Application for a non-material amendment following a grant of planning permission.

Number	
Suffix	
Property name	The Coop
Address line 1	The Parade
Address line 2	
Address line 3	
Town/city	Pagham
Postcode	PO21 4TW
Description of site location must be completed if postcode is not known:	
Easting (x)	489020
Northing (y)	97432
Description

Erection of 1No. 4-bedroom house and 2No. 3-bedroom bungalows including shared use of existing vehicular accesses to convenience store and associated parking.

Reference number:	P/4/18/PL
Date of decision	04/05/2018

PROJECT	Kings Beach	DATE	27/07/18
TITLE	Elevations Plot 2	DRG NO	IBA/505/09/Rev C
SCALE	1 : 50	REVISIONS	A

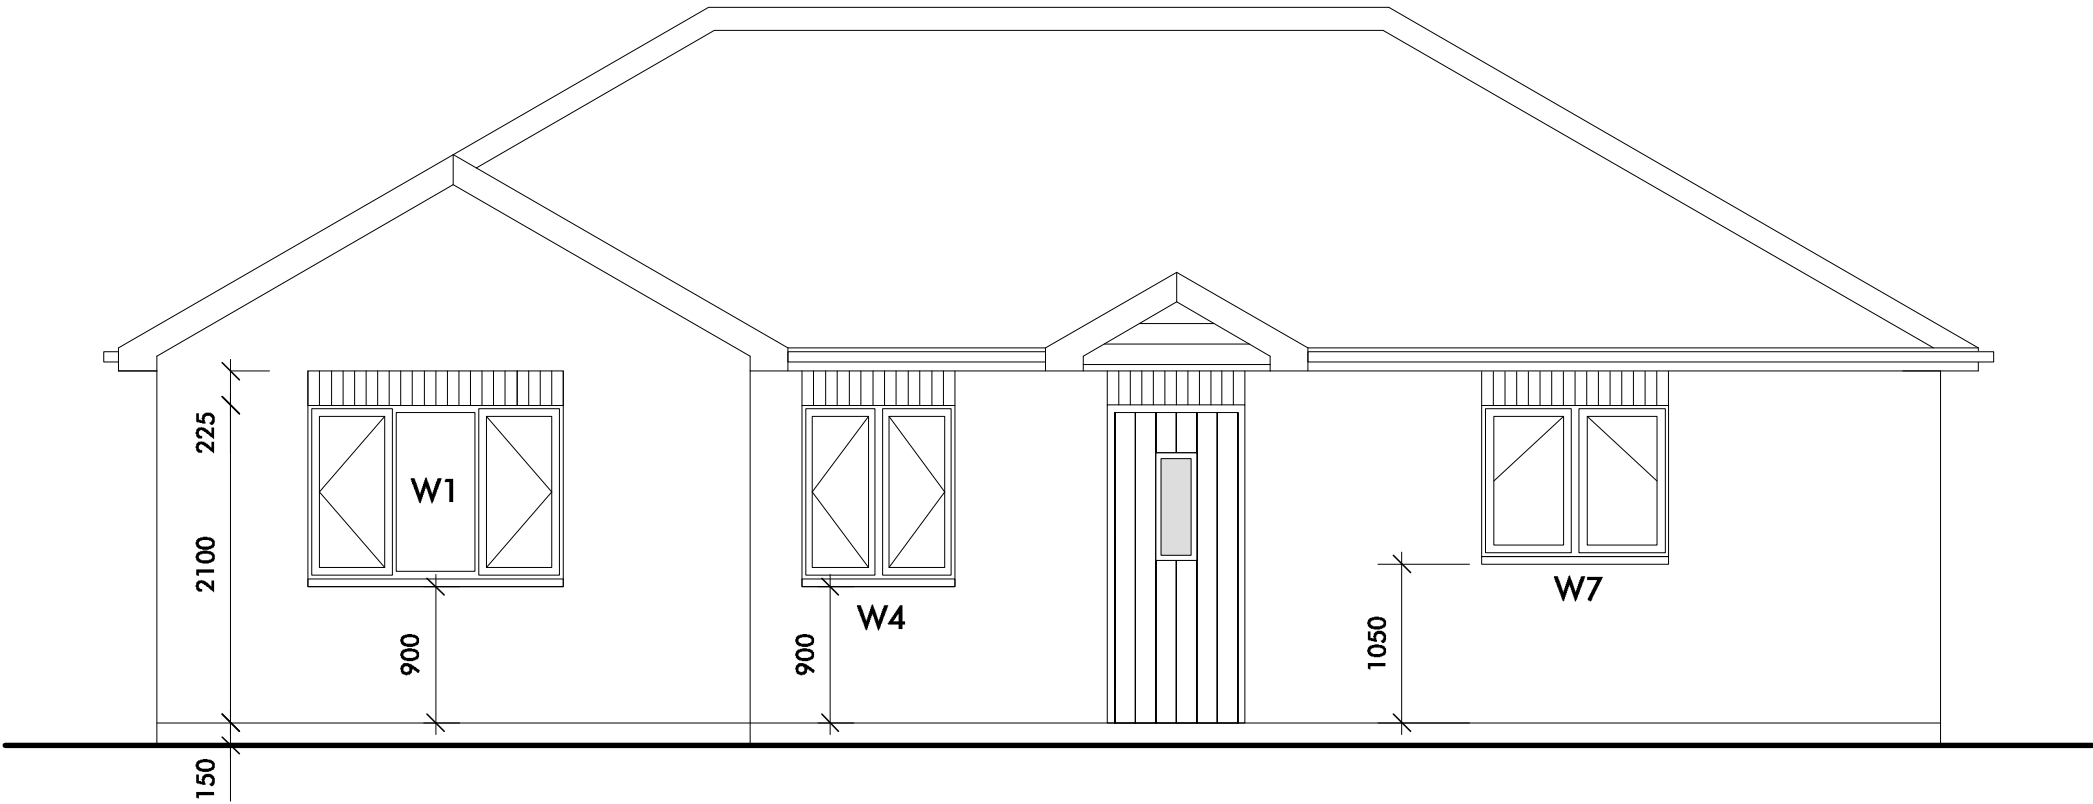
Repositioning of mini roof gable from over the front right window, to over the front door to Plot 2 (former bungalow 1 in planning documentation).

The positioning didn't work out with the positioning of the supported roof trusses. We have overcome this by moving it to the left and positioning it over the front door, which we believe is an improvement aesthetically creating a porch style gable.

IBA/505/09/Rev C (Plot 2 with Gable ove front door)
